From: Sue Howell <Sue.Howell@arun.gov.uk>
Sent: 12 May 2022 17:50
To: Planning.Responses <Planning.Responses@arun.gov.uk>
Cc: Anita Gardner <Anita.Gardner@arun.gov.uk>
Subject: Planning Consultation on: A/45/22/PL

Response to Planning Application

Application ref: A/45/22/PL

Location: Rustington Golf Centre Golfers Lane Angmering BN16 4NB

Appendix A - Site Layout

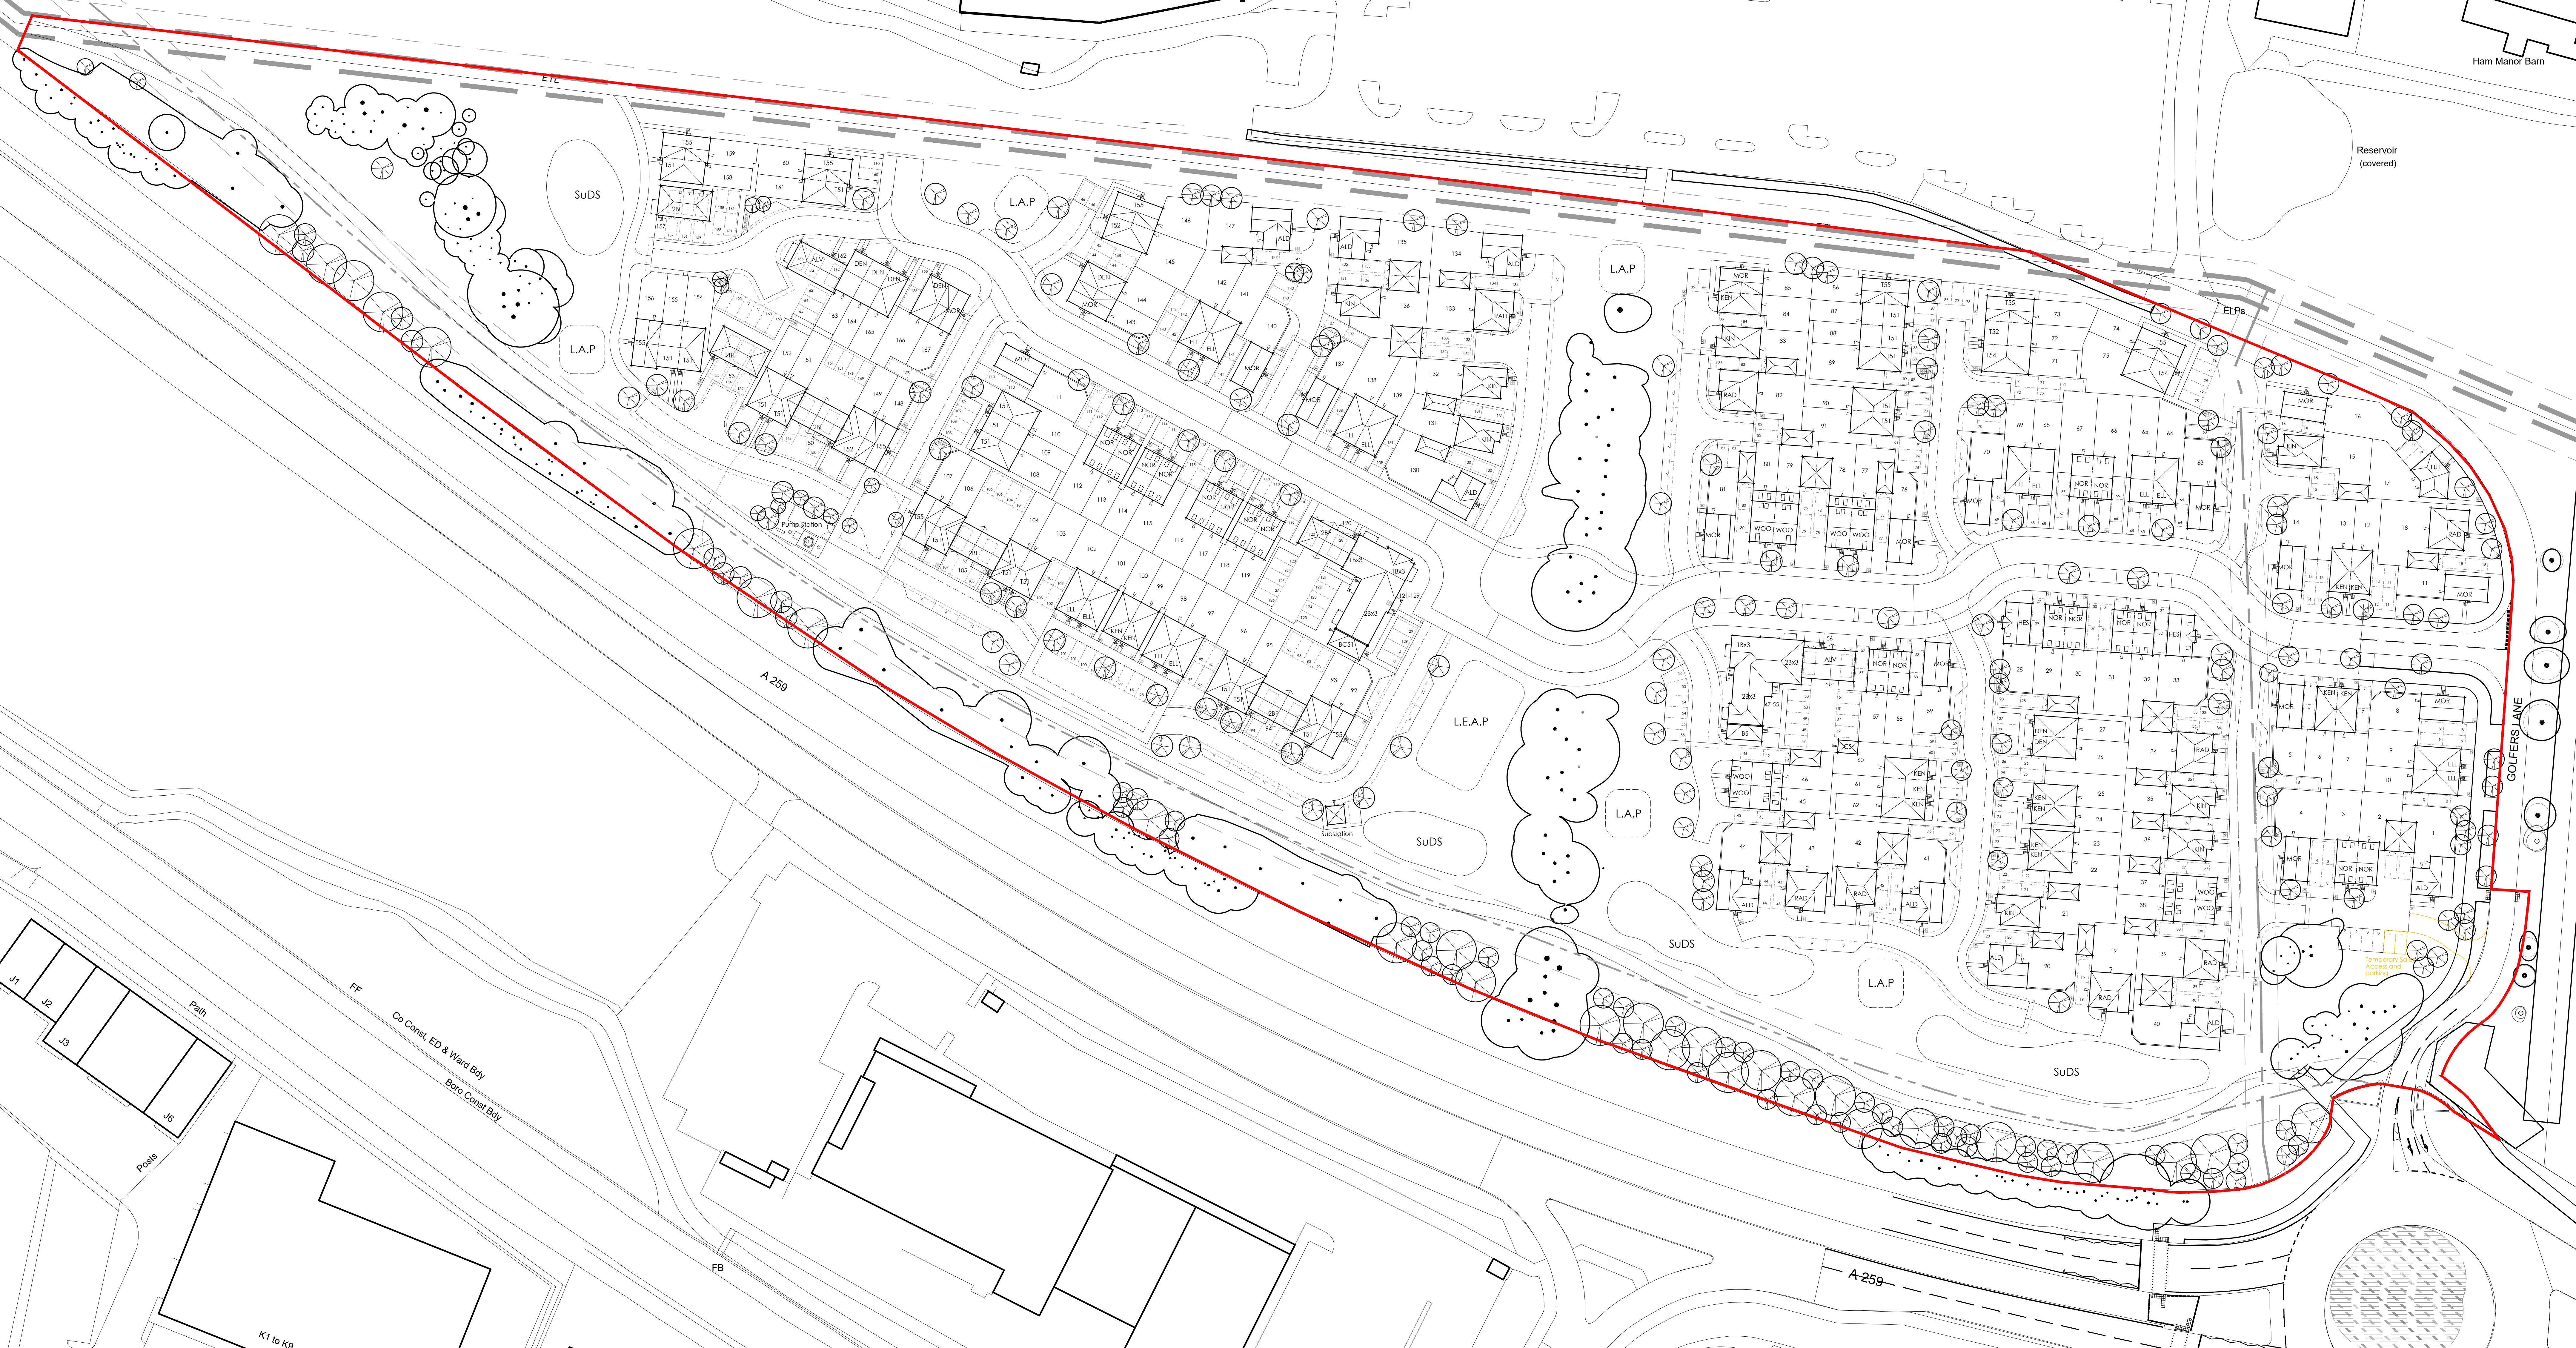
This is a CIL liable development. The indicative layout under this application has shown 167 new dwellings within the proposals with an area of POS, located centrally to the development and some POS buffer planting areas to perimeter, largely to accommodate existing trees. Consideration appears to have been given to positioning dwellings facing onto POS areas in line with good design principles.

The indicated layout under this application A/45/22/PL would appear to show an improved layout regarding POS provision to that submitted under A/120/21/PL where a landscape objection was recommended. Much of the POS provision still however appears to be located around existing tree retention provision/ buffer strip areas and areas shown also for SuDS features, with play scattered in many locations where space will allow, rather than a landscape led development with coherent connection of these features. The play areas appear to have been moved away from bordering the A259 road, which is an improvement with better locations where they can also be surveyed from adjacent dwellings.

The proposed layout shows areas detailed as potential SuDS within the POS area. Any areas of SuDS required for the development should not be included in the total area of usable POS calculations. Further detail would also be required regarding depths and indication of timeframe for water holding periods ie dry feature or water holding body. This would be particularly relevant because of the proximity in relation to indicated play and dwelling boundaries.

The play areas appear to have been located now away from the root protection areas of the trees within the central area where concern was previously raised. Pathway connections to these would need to be detailed (not just mown grass paths) and allow for accessible and inclusive access and play features. Indicative play provision has been shown within the Landscape Design Strategy February 2022, this would need to be confirmed in plan form detailing actual provision, safety surfacing, fences and gates and public realm furniture including seating/benches, bins, signage, cycle racks and dog bin provision.

Pedestrian and cycle routes within the development should be a considered design features and their meaningful connection to beyond the site detailed. There would still not appear to be any meaningful connected pedestrian routes through the site other than the east west pathway shown.
